Recommendation Report for Planning Permission for Works or Extension to a Dwelling

REF NO: FP/23/19/HH

LOCATION: 6 Firs Avenue West
Felpham
PO22 8PZ

PROPOSAL: Roof alterations to provide part new first floor.

sheet 2 of 3

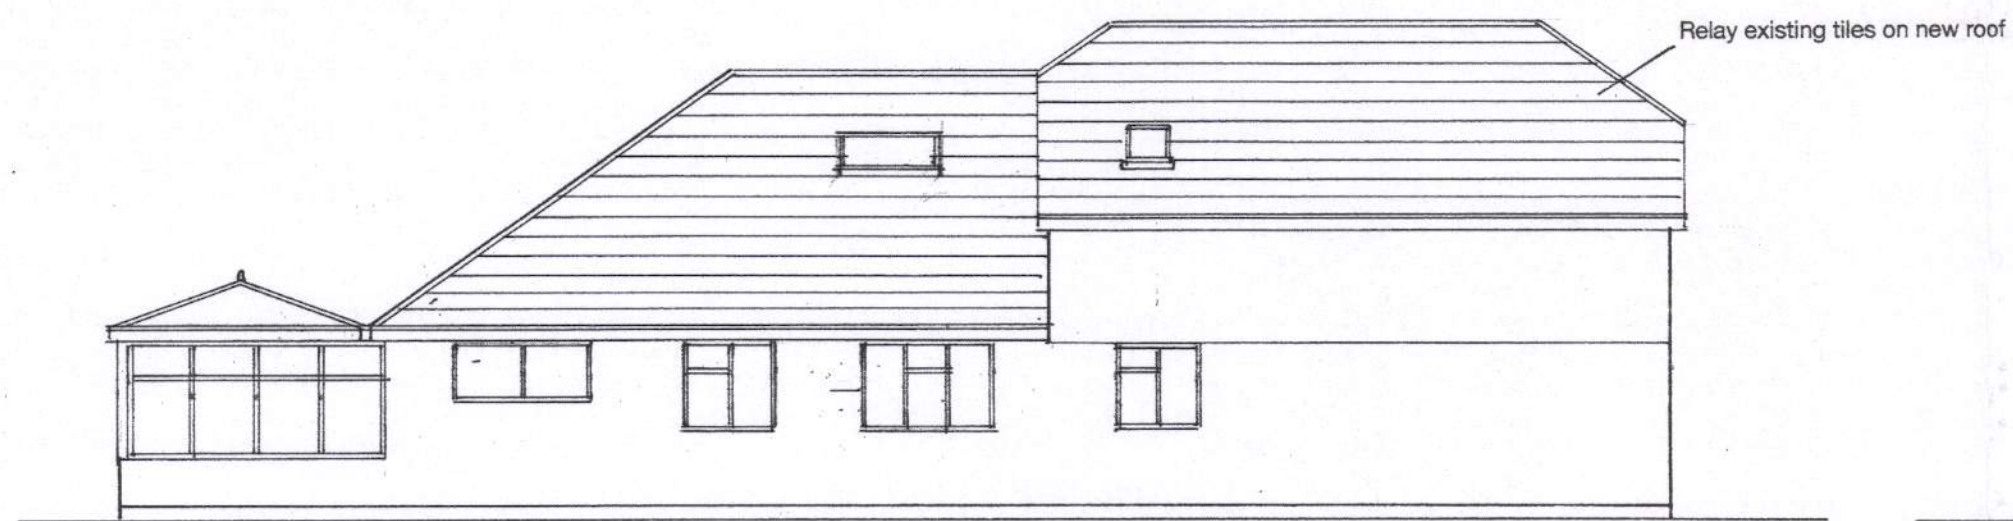
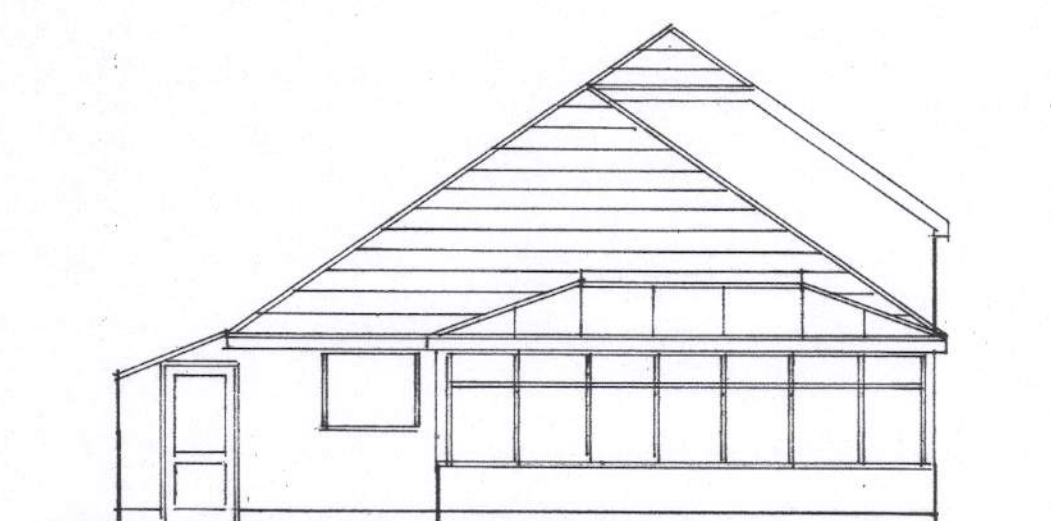
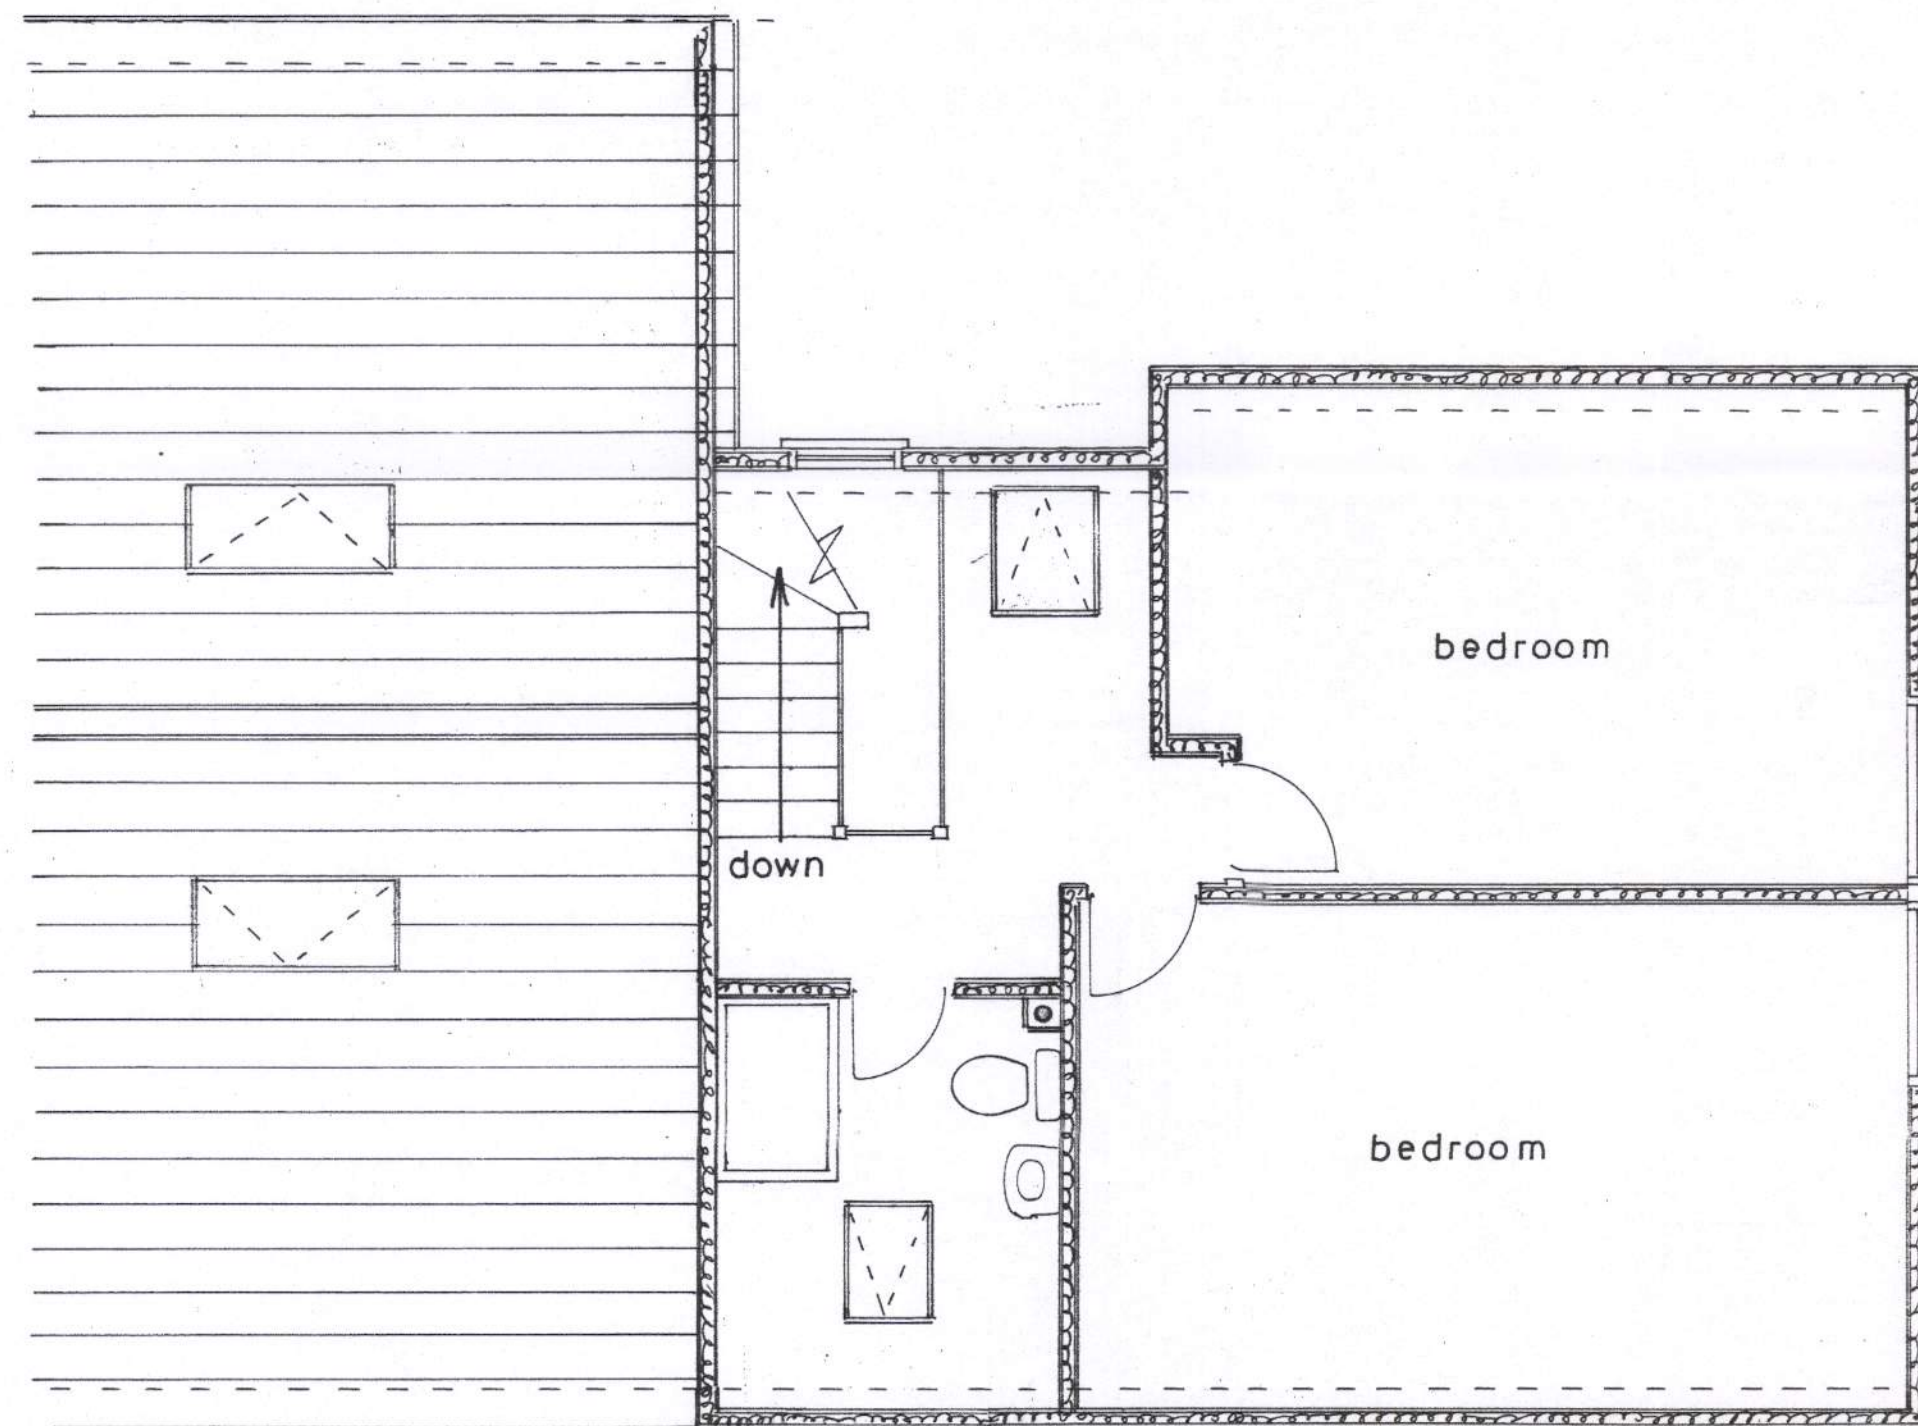
The dwelling is situated to the end of a cul de sac and is a private road. The proposal seeks to create a first floor to the existing bungalow. The roof will therefore increase substantially in height. The eaves height of the dwelling will increase from 2.75m to 4m and the height will increase 2.5m from 4.15m to 6.65m. The height will step down slightly towards the rear however will still increase approximately 1.5m.

The proposed alterations are not considered subservient to the host dwelling and do not relate sympathetically towards the existing dwelling, given that the height of the roof of the original dwelling will be raised throughout. The proposal is therefore in conflict with DDM4 (a) and (b) of the Arun Local Plan.

Due to the increase in height and scale of the property and the resultant change in appearance to the host dwelling the proposal is unacceptably harmful to the design and visual amenity of the area and in conflict with D DM1(1) and D DM4 (a),(b) and (e) of the Arun District Council Local Plan and ESD1 of the Felpham Neighbourhood Plan.

the magnitude of height increase it would result in the dwelling appearing adversely overbearing upon neighbouring properties. This is further intensified as the host dwelling is set forward of both neighbouring properties (No. 7 and No.5) by approximately 4.6m. The increase in bulk to the dwelling will therefore result in an unneighbourly and overbearing impact upon neighbouring amenity namely No.7 due to its siting south of the dwelling.

Whilst the height to the rear is slightly reduced than compared to that of the front addition its pitch is increased which enables an additional 1.5m height increase. Eaves to the rear will however remain as existing.

Due to the height above finished floor level the velux windows proposed to the north and south are not considered to give rise to any adverse overlooking upon neighbouring amenity. A window is also proposed north however with this serving a landing again it is not deemed to give rise to any adverse impacts. An additional window will be constructed to the first floor eastern elevation. This will overlook the street scene and towards 6 Innerwyke close however with the property at single storey there is not considered to be any adverse overlooking.

Due to the siting of the proposal which is set forward of neighbouring properties and noticeably larger in height the proposal is considered to give rise to a significantly overbearing impact and an unneighbourly form of development harmful to the amenity of adjoining occupiers namely No.7 and as a result is in conflict with DDM4 (C) of the Arun Local Plan.
